Our Ref: 20/05262/HFUL
Your Ref: Sally Boss

**South Cambridgeshire District Council
Application for Planning Permission**

Proposal: Demolition of existing annexe building comprising double garage and storage space and erection of garden study/store

Site address: 9 The Leys Little Gransden SG19 3DZ

FRONT ELEVATION.

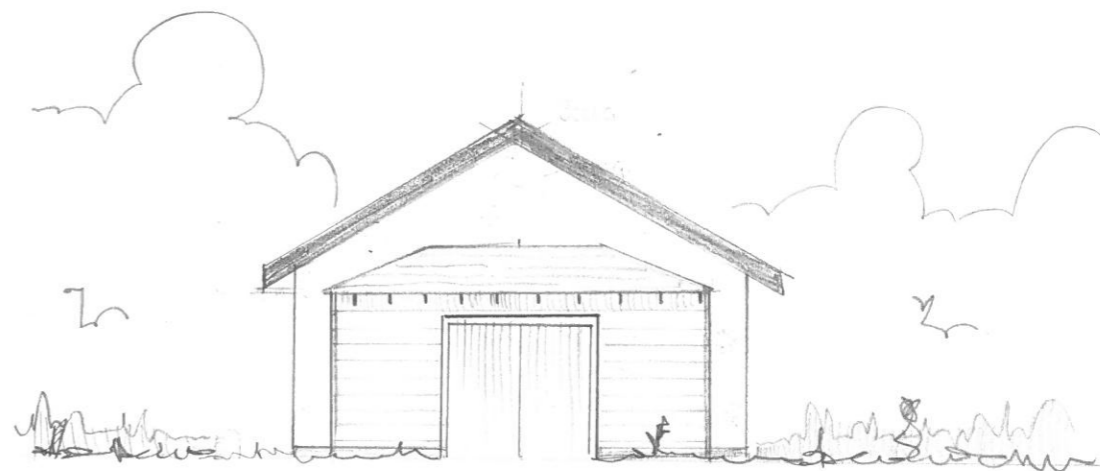
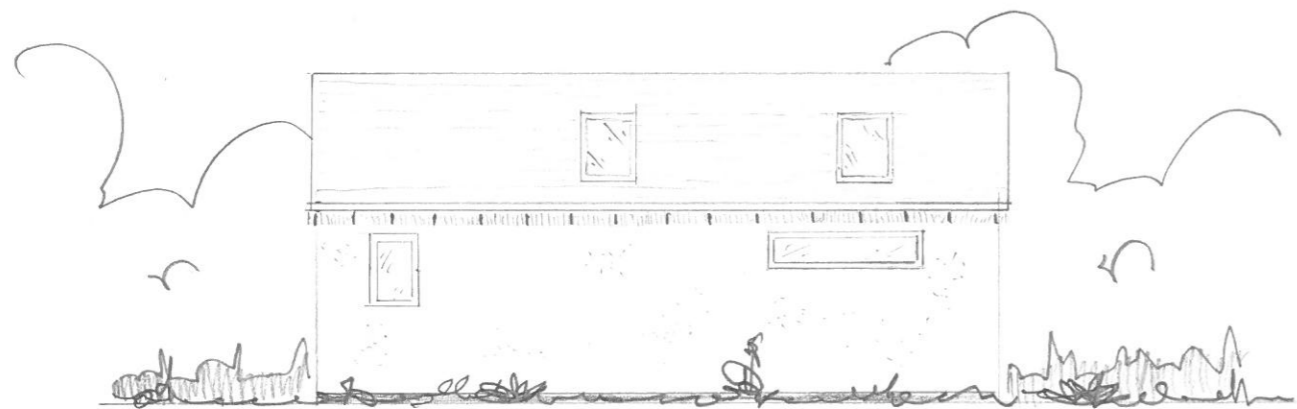
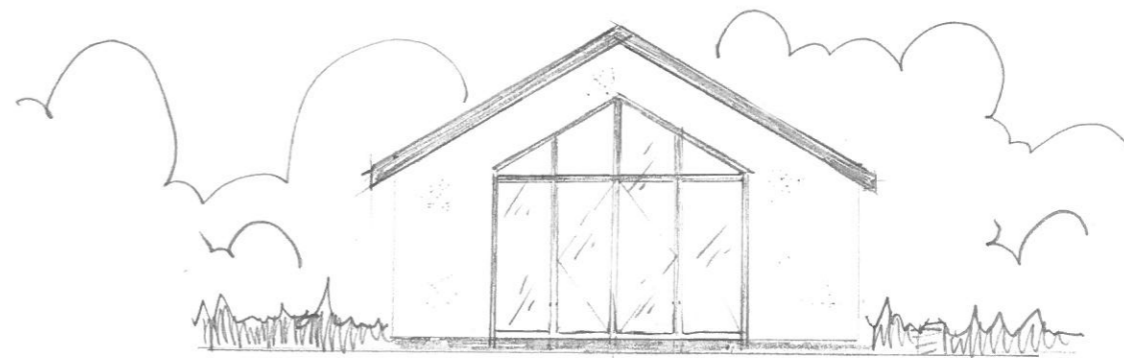
1. Please provide a revised site location plan ensuring it is drawn to a scale as indicated and include a scale bar
2. Please provide revised proposed plans and/or elevations ensuring all windows and doors indicated on the floor plan and elevations match.

Please also include a scale bar on the proposed elevations drawing
3. Please provide existing floor plans and elevations of the existing outbuildings for demolition drawn to a scale of 1:50 or 1:100
4. Please provide a revised block plan ensuring it is drawn correctly to scale and shows sites boundaries as per the location plan and the proposed development clearly shown in a different color to red or blue.
